From: Patrick Galbraith-Robertson [REDACTED]
Sent: Monday, 28 June 2021 4:42 PM
To: Jenny Chu
Cc: Erin White
Subject: RE: Port Macquarie-Hastings Council feedback on Hastings Secondary College (SSD-11920082)
Attachments: NSW Dept of Education and Training, 16 Owen Street, Port Macquarie, 28-Jun-2021.PDF

Thankyou for the opportunity to provide comments regarding the proposed the Hastings Secondary College and PCYC SSDA.

DRAWING LIST

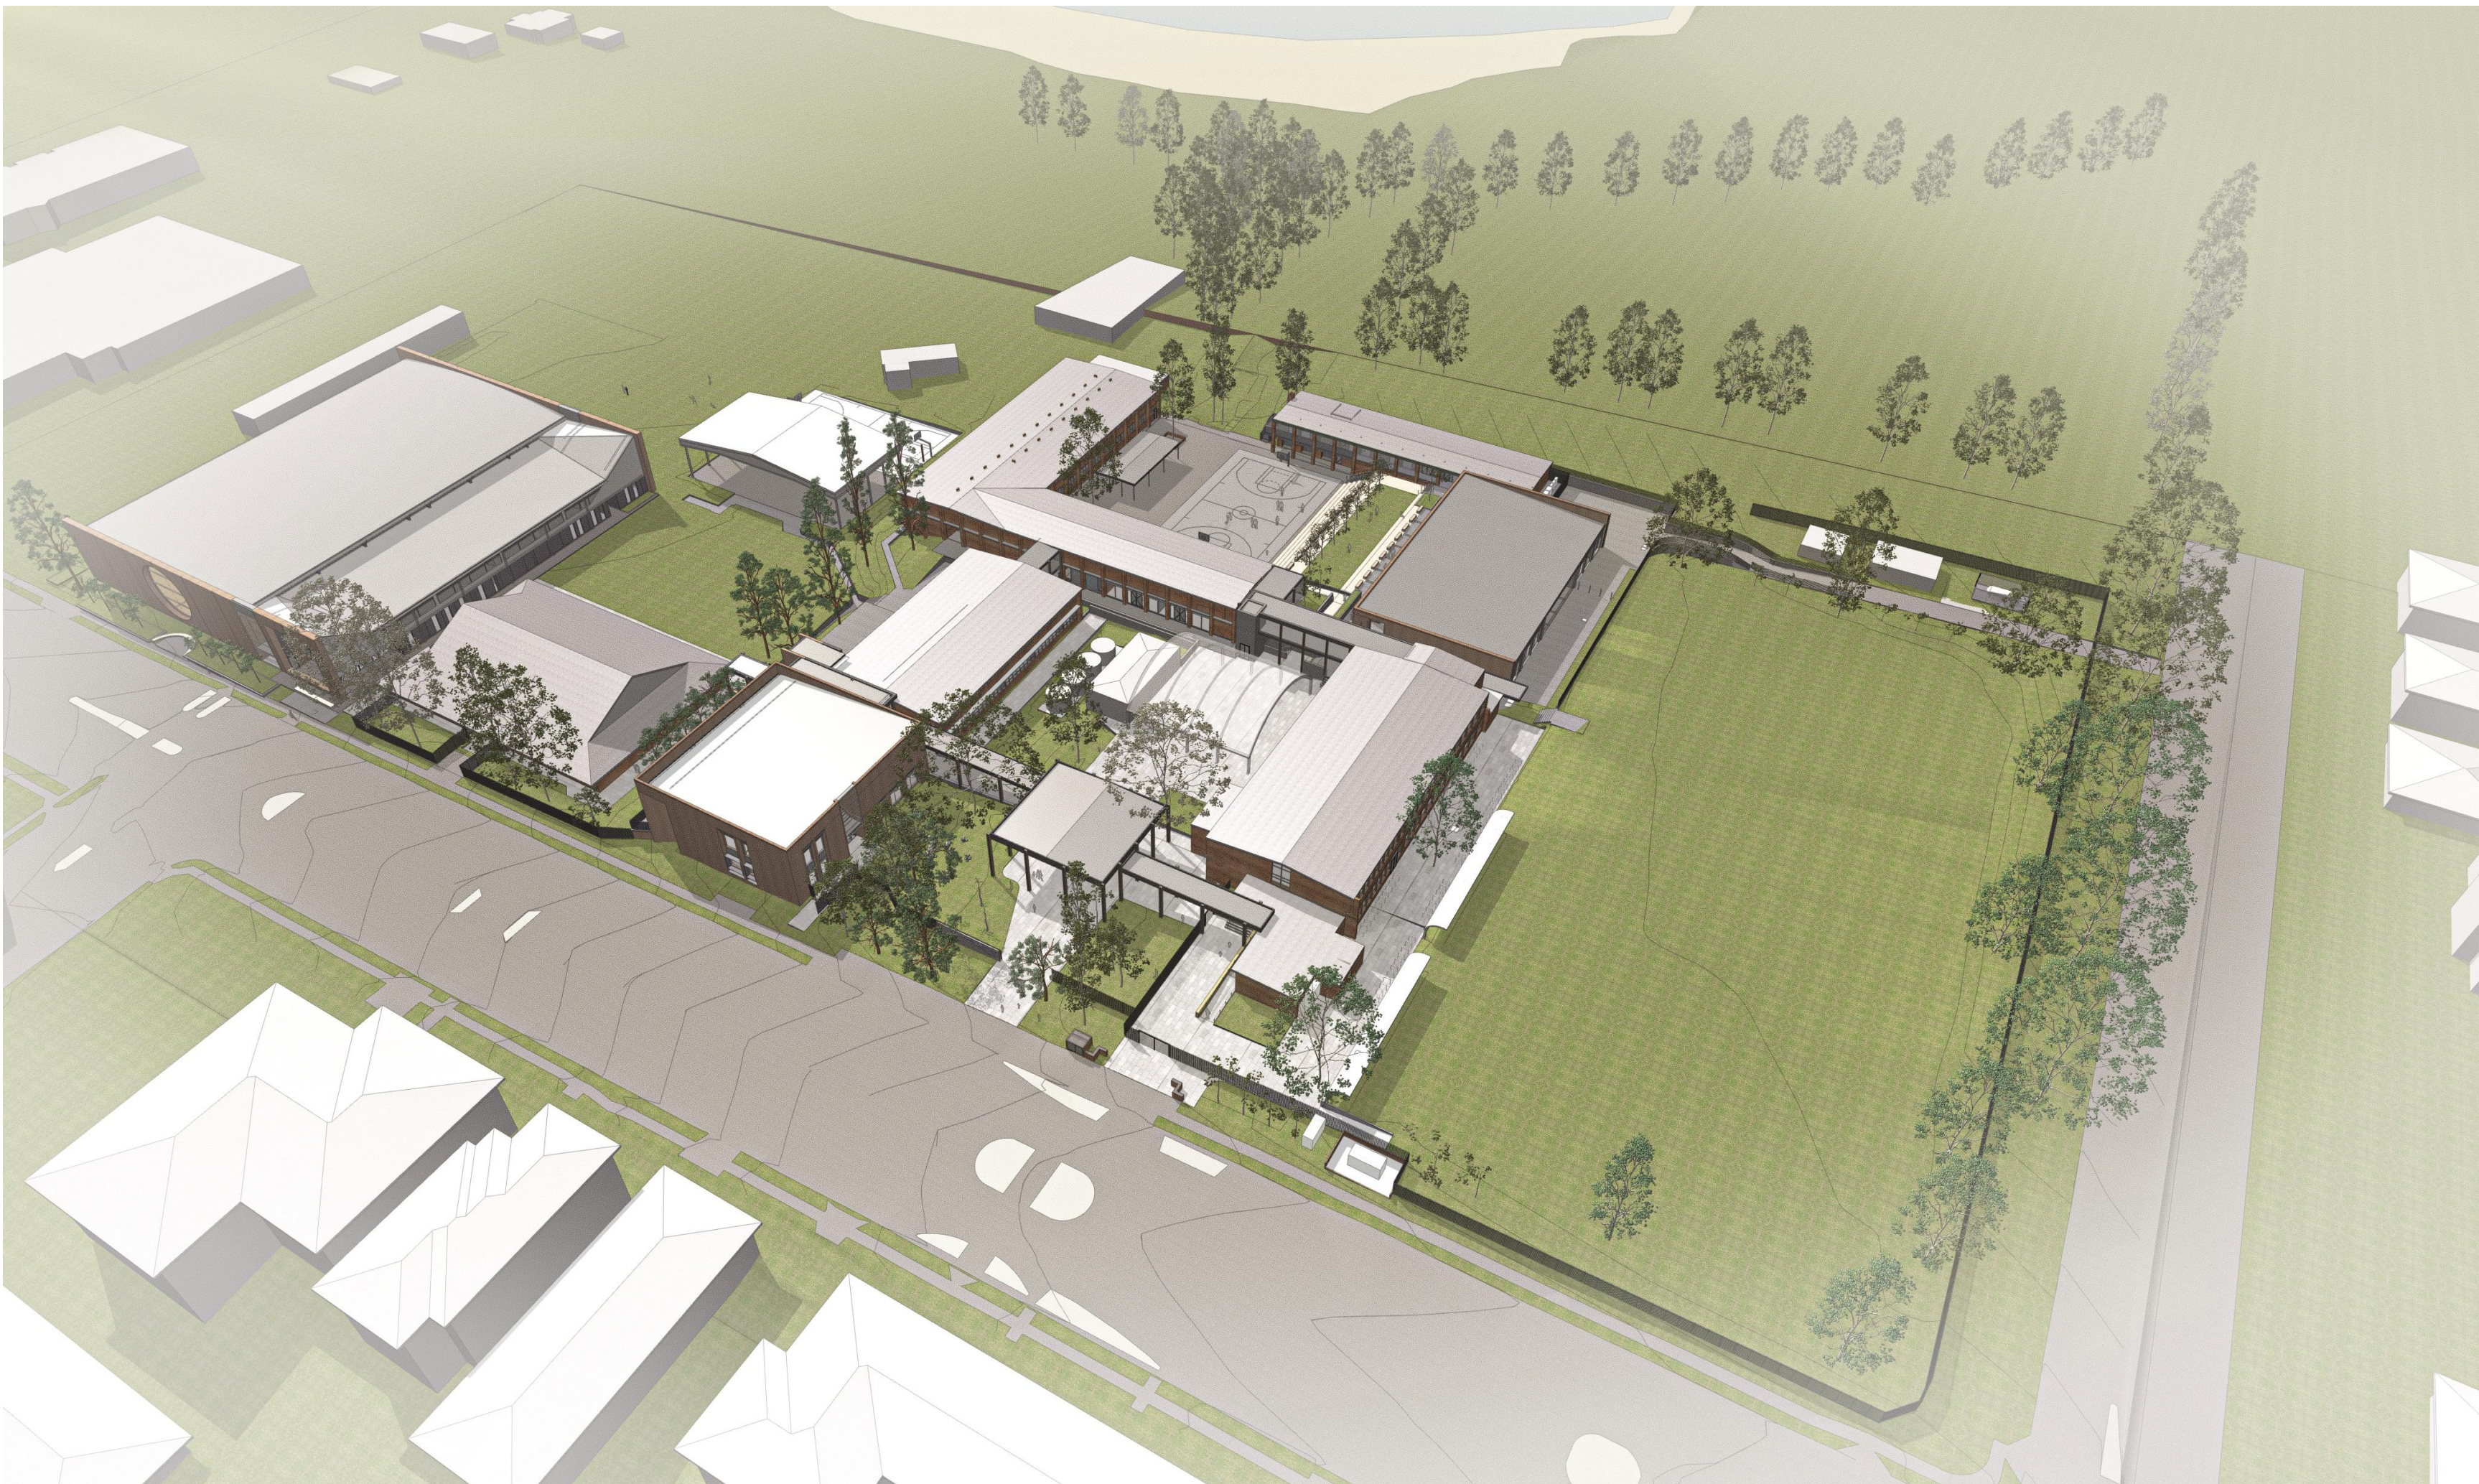
- Excellent to see that many local native species are utilized in the design with a good selection of species and diversity.
- Could consideration be given to replacing Swamp gum (*Eucalyptus ovata*) with a local species such as Swamp mahogany (*Eucalyptus robusta*).
